Road Safety Audit Response Report

Client	Avant Homes
Project	Thurnscoe Bridge Lane, Thurnscoe
TPS Reference	P2423
Date Prepared	10.07.25
Prepared By	JT
Checked By	JA

Road Safety Audit Stage 1

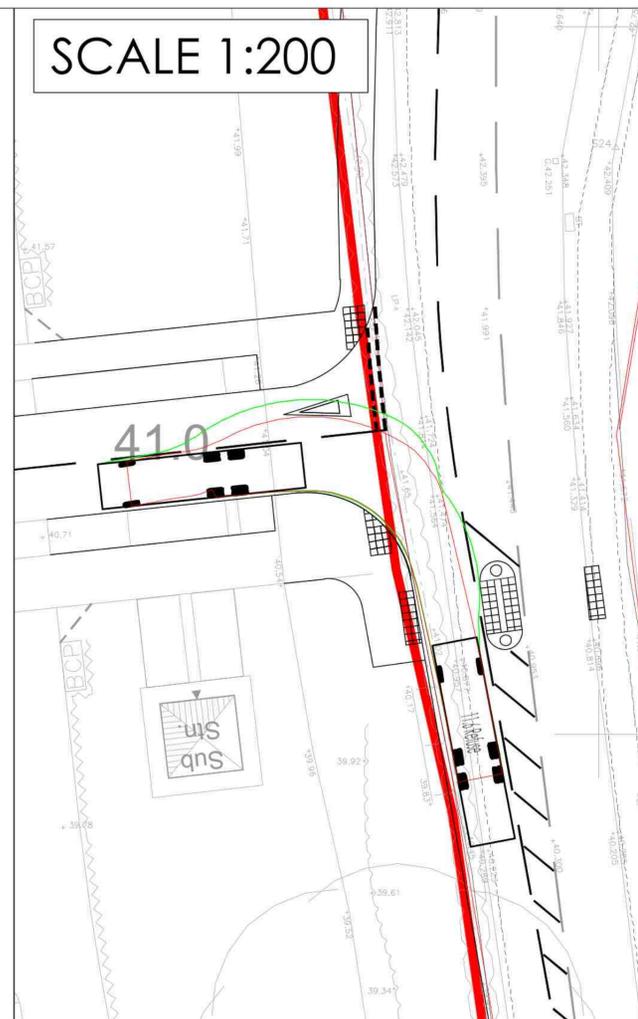
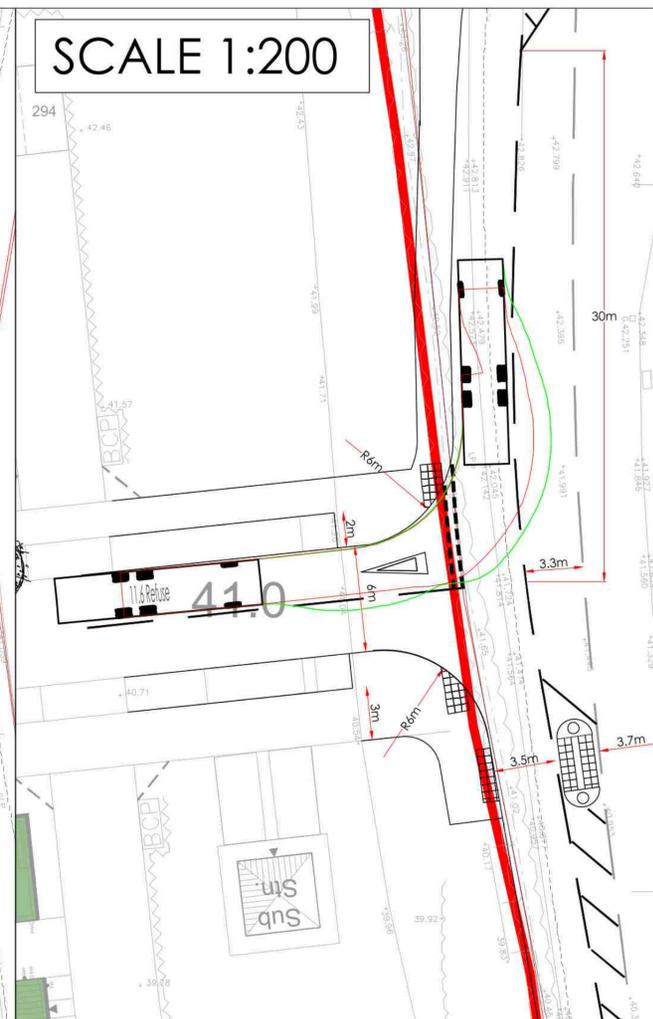
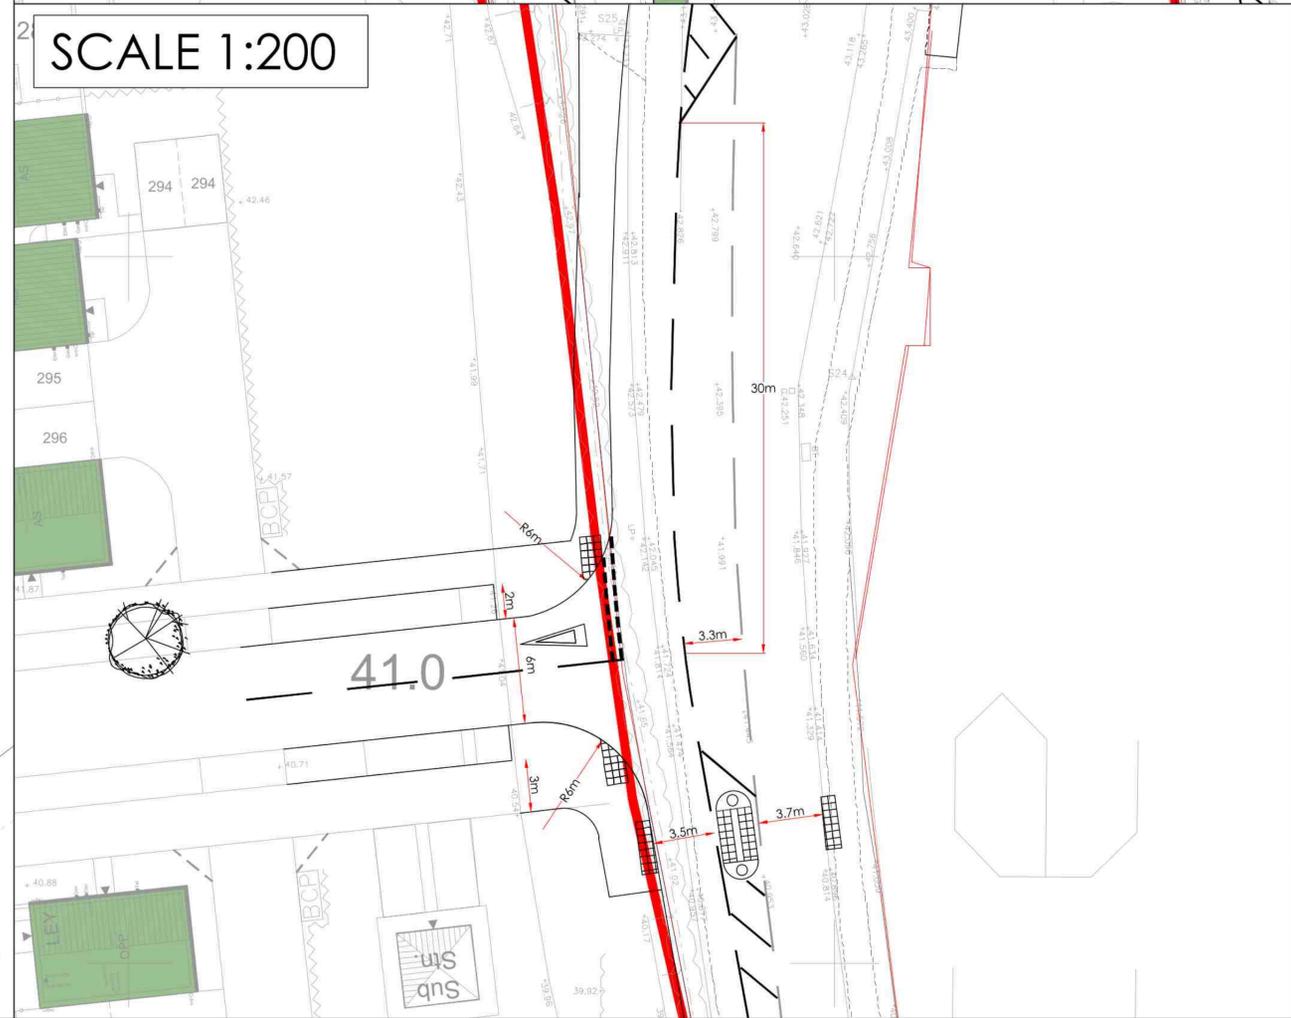
RSA Problem	RSA Recommendation	Design Organisation Response	Overseeing Organisation Response	Agreed RSA Action
<p>A-01 - Thurnscoe Bridge Lane – South of the development access.</p> <p>Landscaping – Future growth from trees and bushes may obstruct visibility consequentially increasing the risk of junction related collisions.</p> <p>No junction visibility has been indicated on the development access. Whilst this will be sufficient to the north, provision to the south when considering the likely speed of vehicles transitioning from the semi-rural section is likely to require some removal of landscaping. The audit team consider that speeds may be greater than a typical 30mph road on this approach. Future growth from remaining trees and bushes to the southern side of the development access may obstruct visibility consequentially increasing the risk of junction related collisions.</p>	<p>It is recommended that the extents of junction visibility at the development access is established and kept clear of any obstruction that may grow or mature in future years and that the extents of the visibility is clearly marked to aid future maintenance.</p>	<p>Agreed.</p> <p>Visibility splays have been added to the proposed access arrangement drawing which demonstrate that 2.4m x 43m visibility splays can be achieved, commensurate with the posted speed limit on Thurnscoe Bridge Lane.</p> <p>This will aid the future management of the vegetation which fronts onto Thurnscoe Bridge Lane, in that it will be ensured that no vegetation over 0.6m in height obstructs the line of the visibility splay.</p>

<p>A-03 - Thurnscoe Bridge Lane – Main carriageway.</p> <p>Skidding Resistance – Carriageway surfacing across part lane widths may increase the risk of loss of control type collisions.</p> <p>The drawings indicate that carriageway widening is to be provided with no indication of resurfacing of the existing carriageway nor what skidding resistance is to be provided. There is a risk here that, if widening is provided by means of haunching the carriageway width into the verge, a differential skidding resistance is introduced between the new and old carriageway surfacing. This difference in skidding resistance may increase the risk of loss of control type collisions, especially when the carriageway surface is wet.</p>	<p>It is recommended that the widening provided is done so in full lane widths and the revised crown of the road is located such to avoid the application of any adverse camber.</p>	<p>Agreed.</p> <p>As part of the S278 detailed design, it will be specified that resurfacing is done across the full width of the carriageway over the length of the proposed works.</p>

<p>A-05 - Thurnscoe Bridge Lane – At the pedestrian refuge.</p> <p>Cycles – Width provision for cycles may increase the risk of shunt or side swipe type collisions involving this user group.</p> <p>Details of kerb-to-kerb widths have not been provided at the proposed refuge. At this location, cyclists may be at risk from motor vehicles passing too close due to a potential ambiguity of width as they overtake the slower moving cycle. This would be especially a problem for northbound</p>	<p>It is recommended that, as per advice in LTN 1/20 Chapter 7, that widths between 3.1m and 3.9m may encourage close overtaking by motor vehicles at pinch points and should be avoided. It is also recommended that wider provision is made for the northbound, uphill direction.</p>	<p>Agreed.</p> <p>The proposed design has been amended to ensure that a width of 3.9m has been provided adjacent the proposed crossing location, in order to be outside of the 3.1m-3.9m distance suggested to be avoided in LTN 1/20.</p>
